From: Paul Cann [REDACTED]
Sent: 05 June 2020 09:45
To: Graham Boston
Cc: Sarah Burrow; James Cook; Chris Martin; Simon Lane
Subject: RE: 9261 - Lineside Industrial Estate, Eldon Way, Littlehampton (P19-439)

From: Paul Cann [REDACTED]
Sent: 18 May 2020 16:30
To: Graham Boston [REDACTED]
Cc: Sarah Burrow [REDACTED]; James Cook [REDACTED]; Chris Martin

From: Graham Boston [REDACTED]
Sent: 01 May 2020 12:03
To: Paul Cann [REDACTED]
Cc: Sarah Burrow [REDACTED]; James Cook' [REDACTED] Chris Martin
[REDACTED]; Simon Lane [REDACTED]
Subject: 9261 - Lineside Industrial Estate, Eldon Way, Littlehampton

Drainage Details Sheet 1

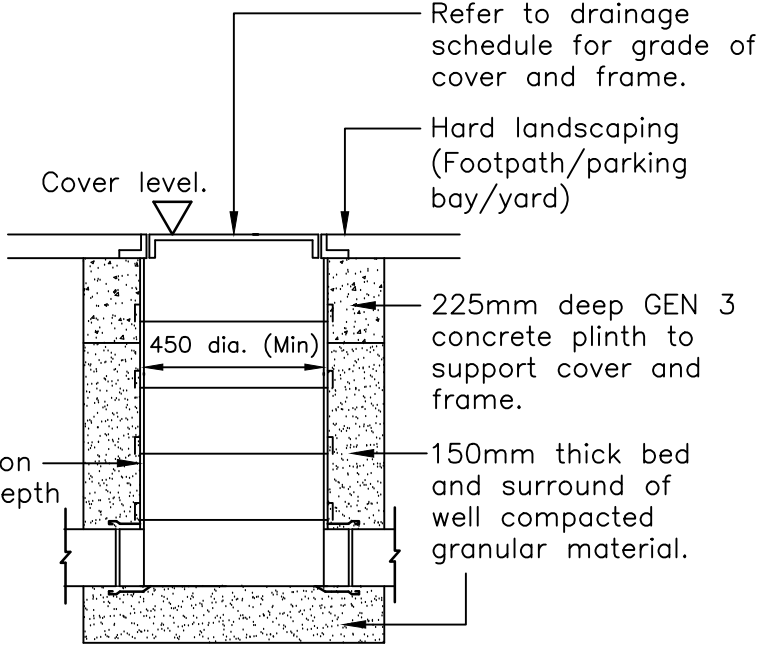
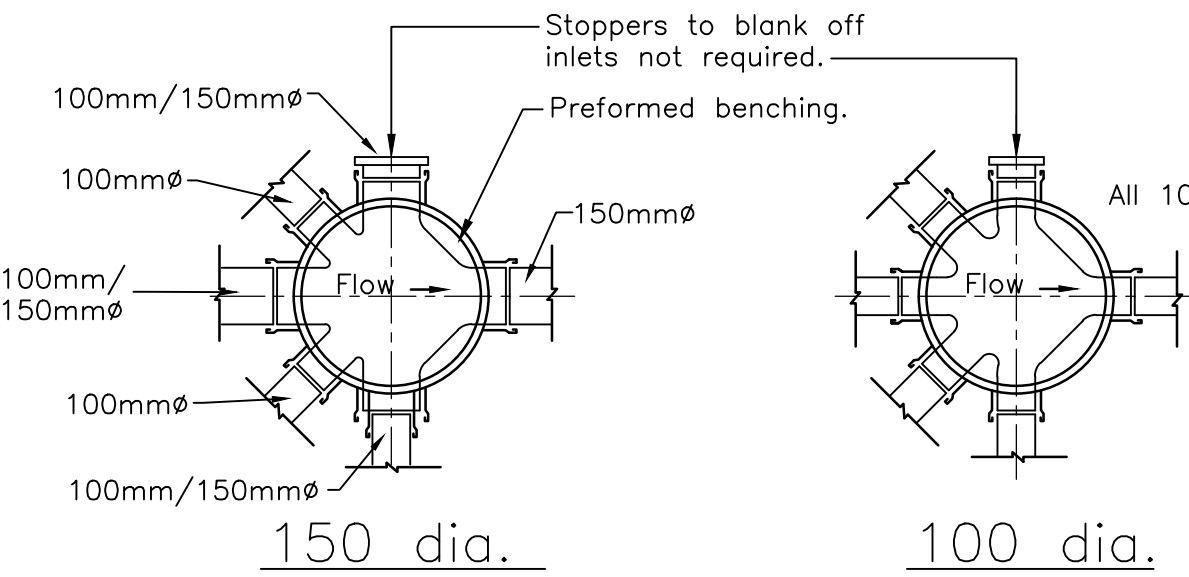
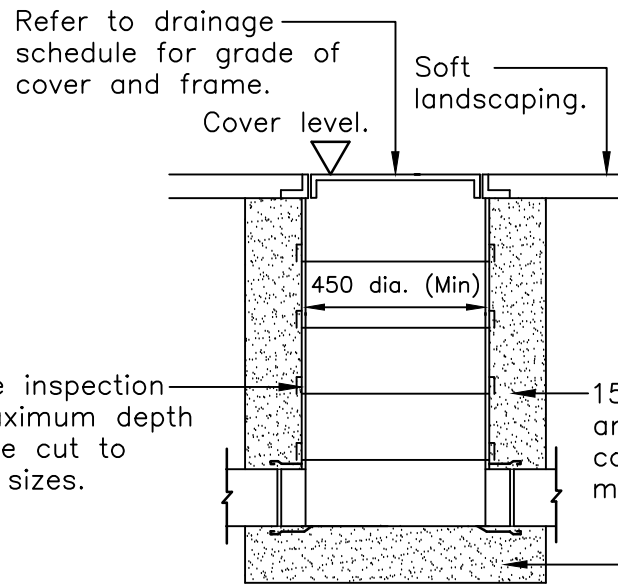
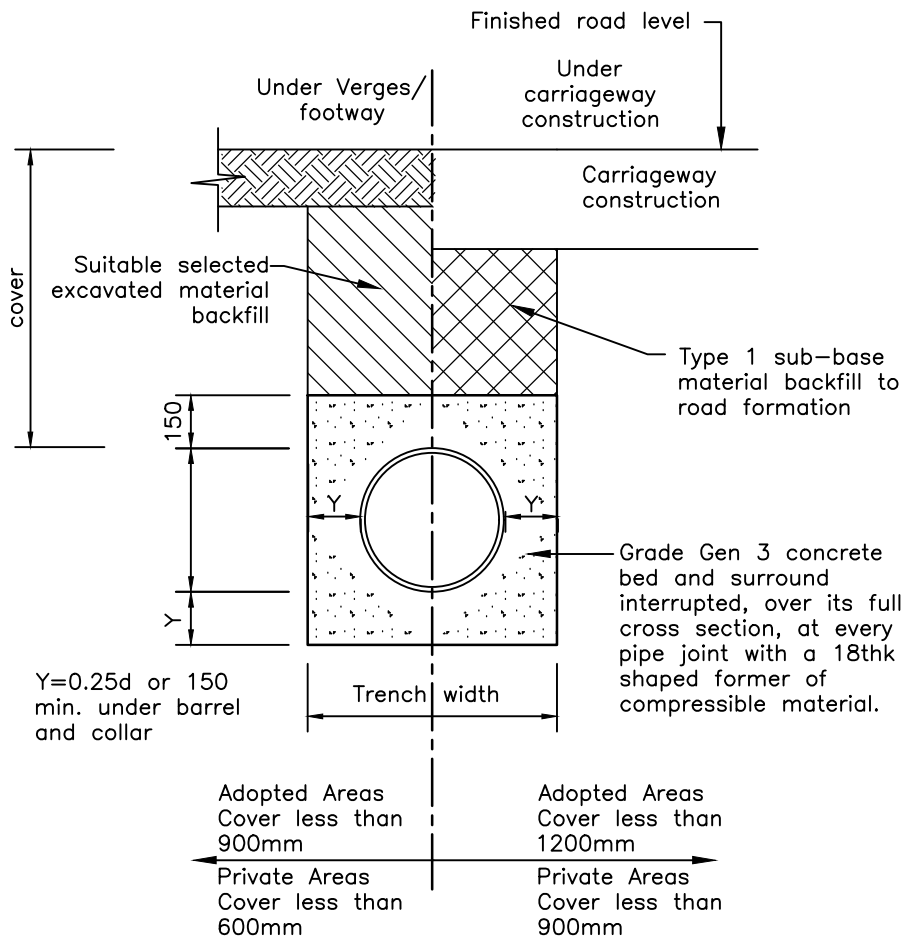
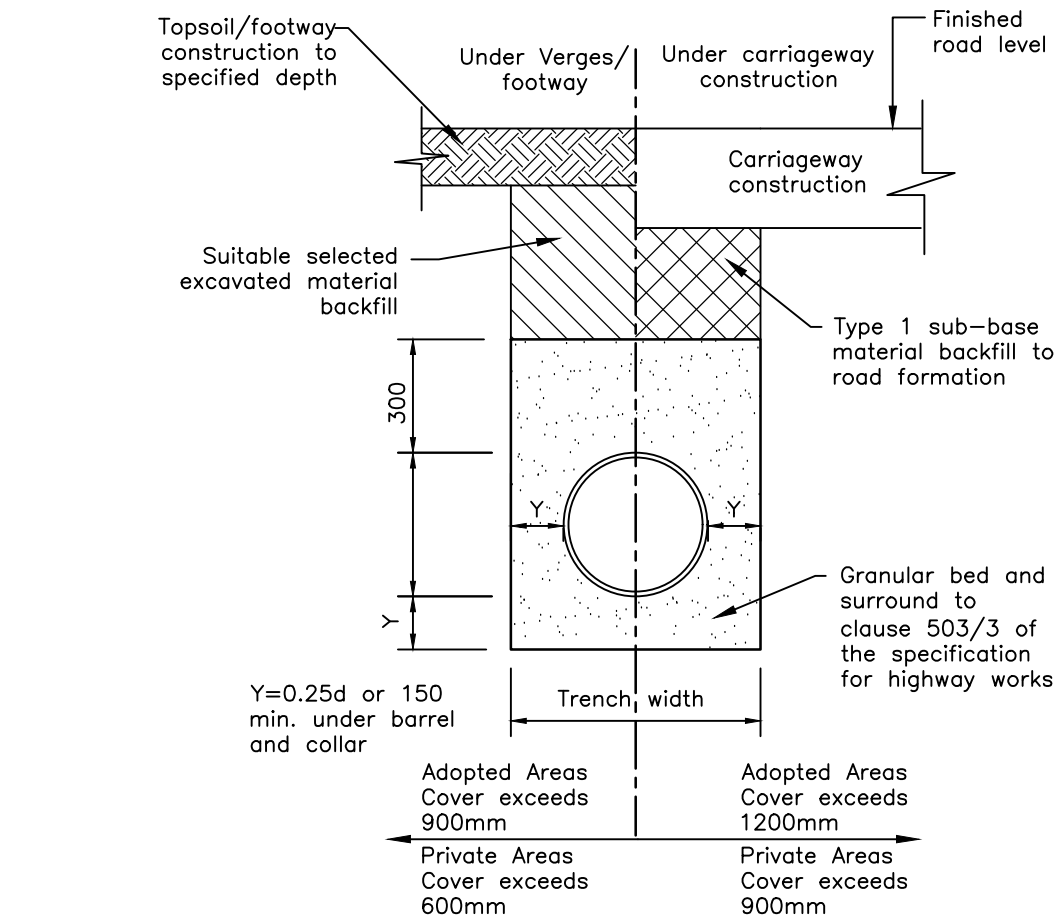
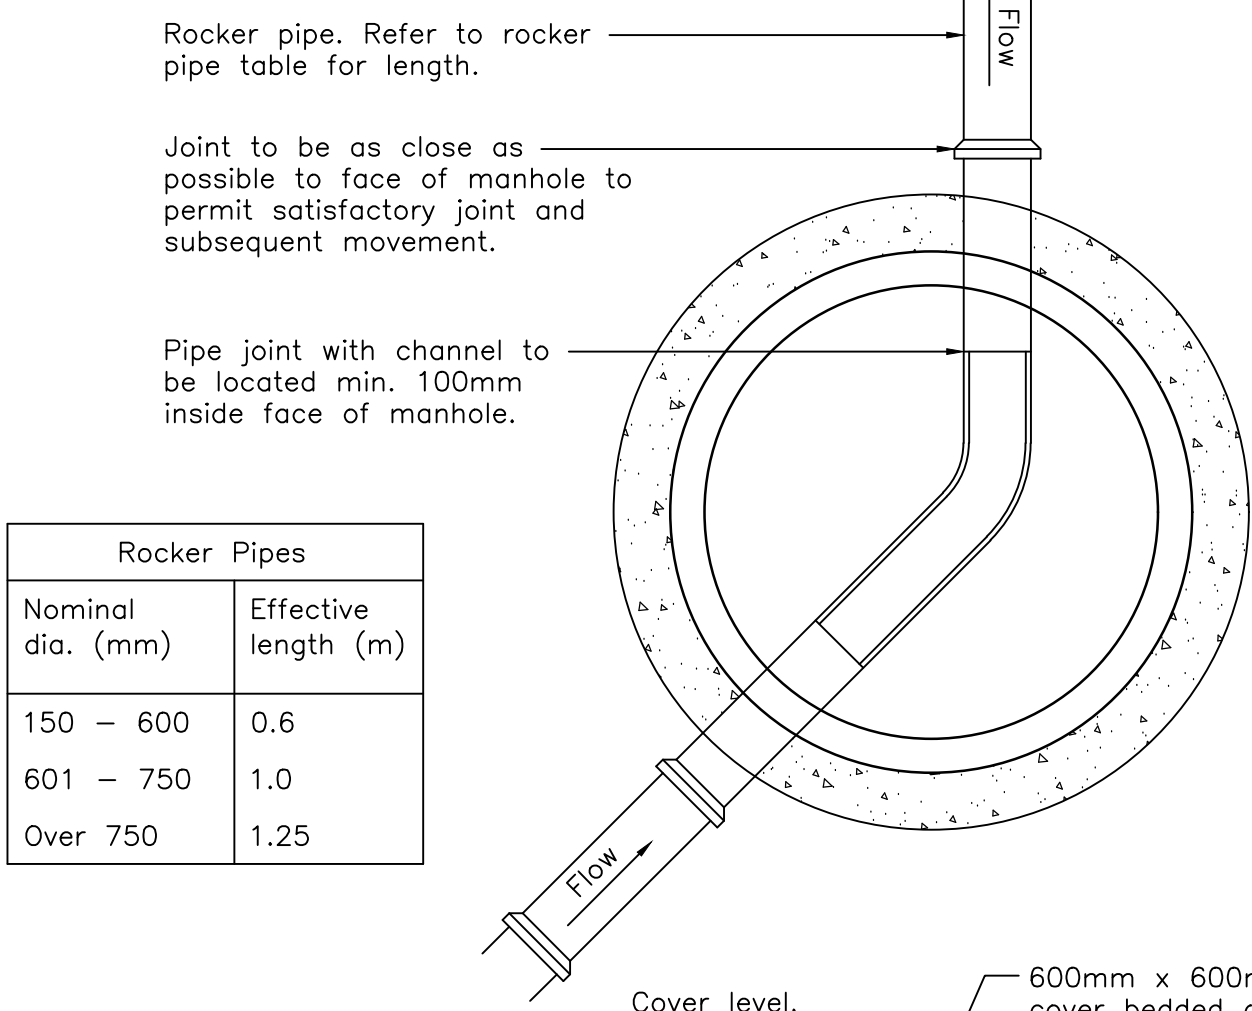
7. Silt trap manhole construction detail – whilst shown on section A-A of the soakaway. Provide a standalone fully detailed construction detail to cover all silt traps.
Catchpit detail to be added.

Drainage Layout
Soakaway Design

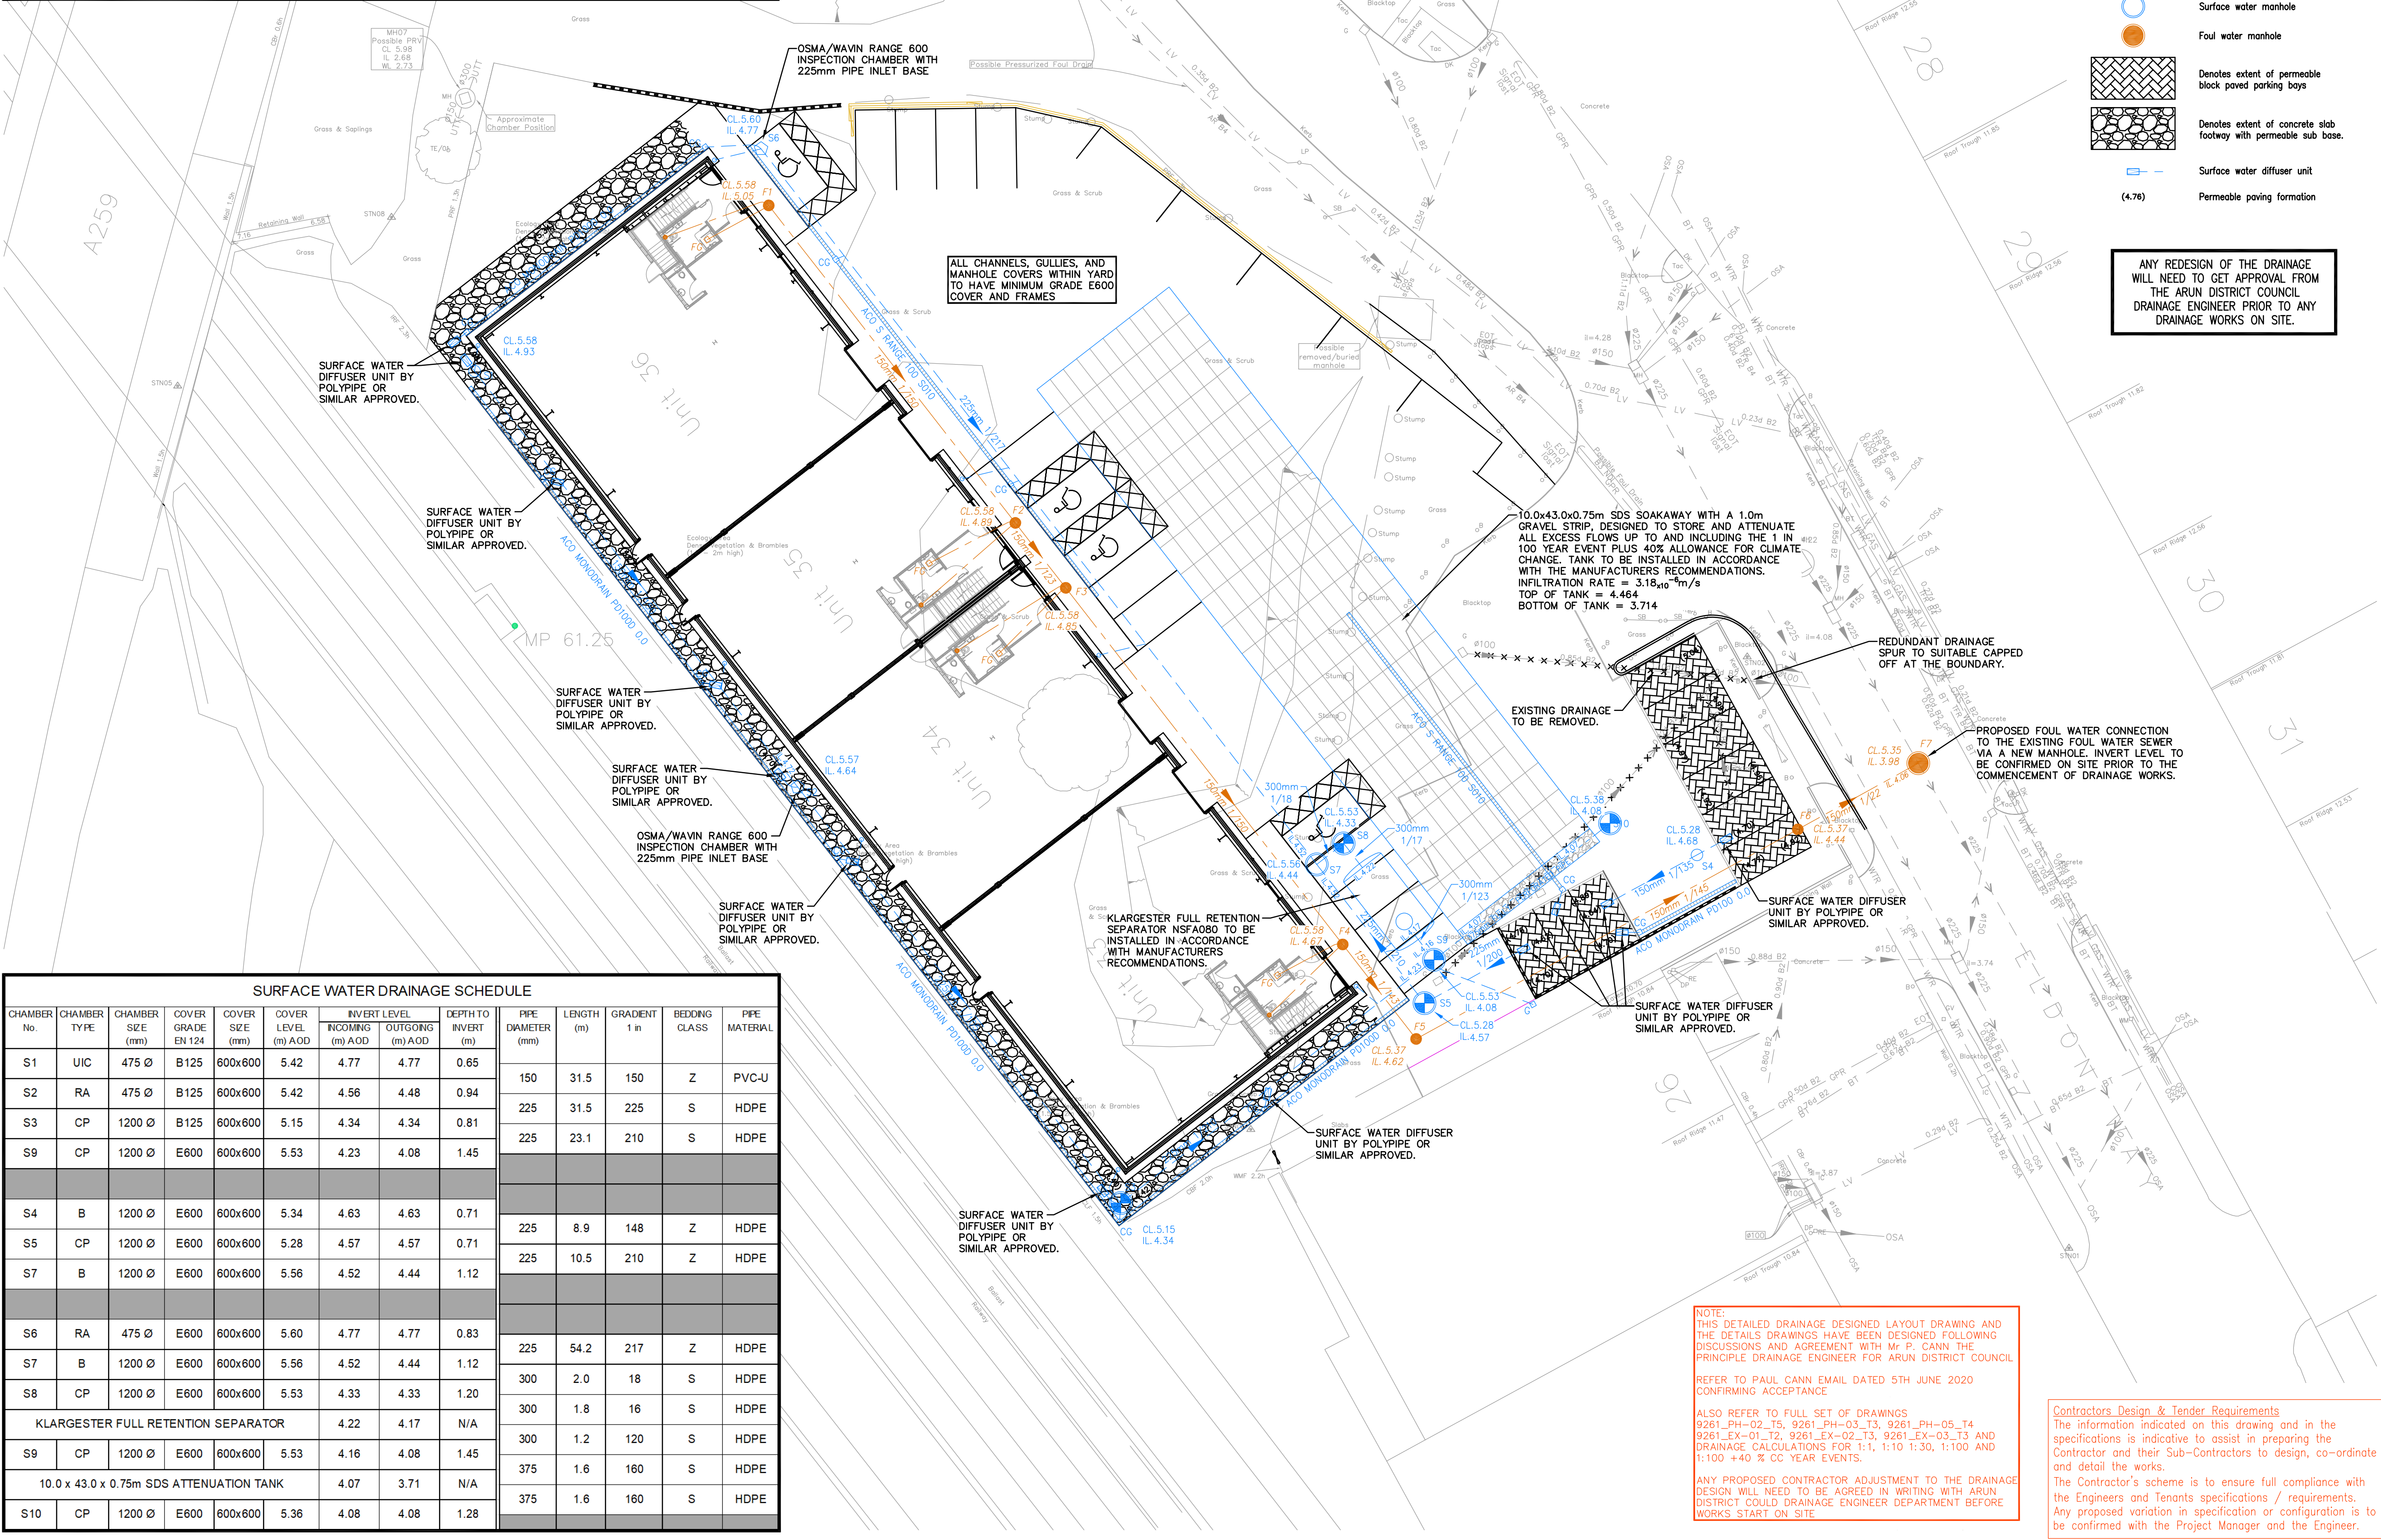
In respect to item 10, you could be looking at around 30mm clearance between the underside of one pipe and the crown of the other, depending on pipe thicknesses. Obviously, if revisions are required on site due to things being too tight, then please contact us to agree any changes.

3. Abandoned surface water drainage – cap pipe at boundary – add note.
Note added
4. Rather than utilising perforated distribution pipes in the footpath to serve the channel drains, please specify a diffuser unit instead ie. polypipe or similar approved. Alter plans and construction details accordingly.
Diffuser units added.

5. Specify channel drain model/sump units/gradients/levels.
Channel specification added.
6. All connections not made to manholes to connection via 45 degree oblique junctions – add note.
Note added.

8. Manhole S8 to be a silt trap.
Manhole S8 updated to a catchpit manhole
9. Show finished surface levels/falls and finished floor levels.
Refer to 9264_EX_01 Levels Layout

10. Pipe crossing just downstream of manhole S5 – freeboard between the two pipes is very tight – scope for increasing freeboard?
<100mm between soffit and invert of crossing pipes.

11. Outlets from permeable paving to be via diffuser units, therefore remove perforated pipework.
Diffuser units added.
12. Permeable paving – specify base and finished surface levels on plan.
Formation levels added.

13. Granular surround to perforated crate soakaway distribution pipe – specify grading.
Granular surround specified.
14. Is a further gully required within the paving slab footway? ie. near section D-D? Assuming the path falls in that direction.
Ground levels fall towards proposed gully.
